From: Katherine Rawlins
Sent: 14 November 2011 15:59
To: Planningecons
Subject: FW: Condition AW/237/11/DOC

We have a discharge of condition application (above ref) the condition no. 4 relates to the requirement for a method statement regarding the storage of plant etc to preserve the health of trees.

CONTRACTOR'S SITE COMPOUND drw.

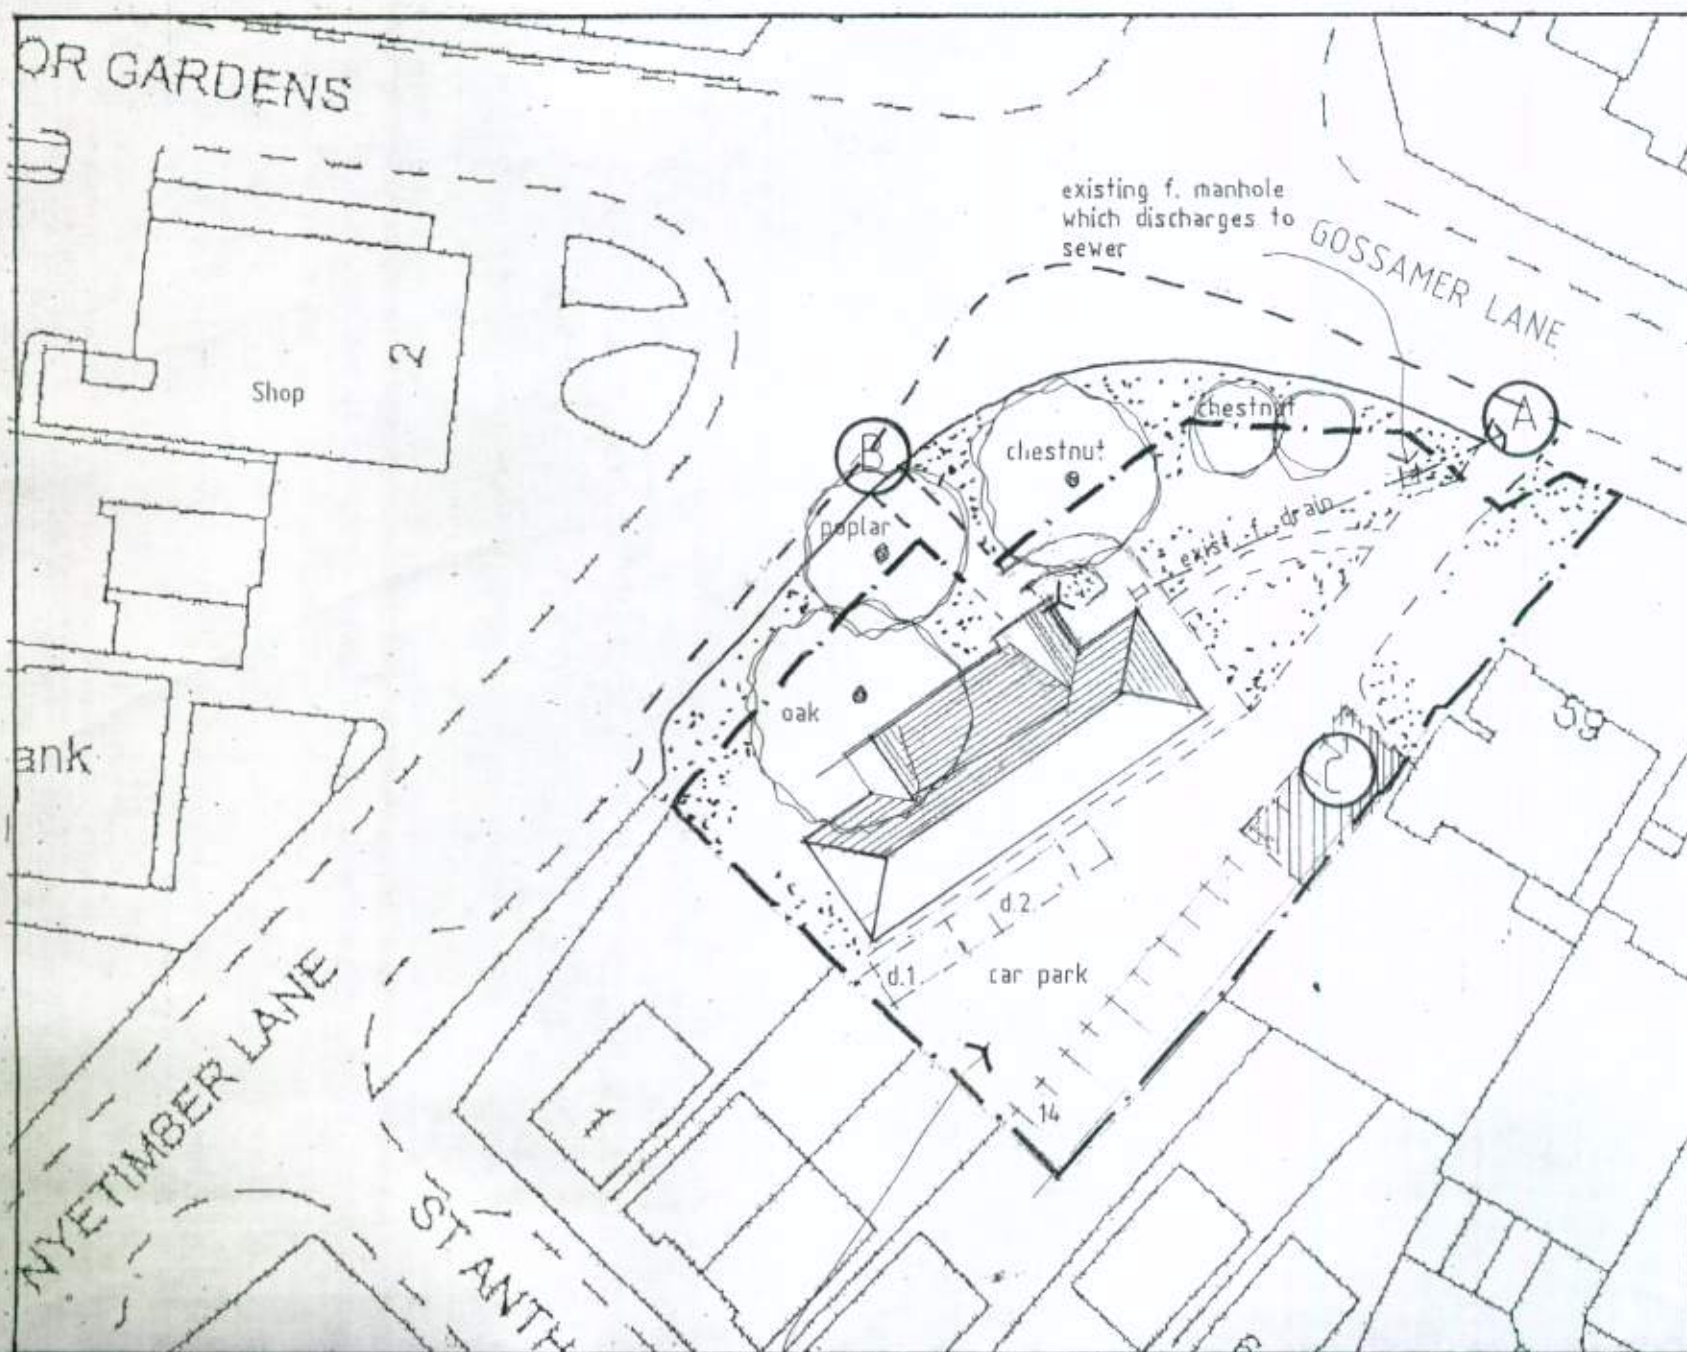
the storage of plant within the Area C as marked on the Studio 5 architects Ltd. (job no. 10.530) plan within the car park is at a sufficient distance to not impinge adversely upon the health of the three protected trees which are located to the north west of the Church. I therefore accept that an appropriate area for plant and storage has been identified according to Condition 4.
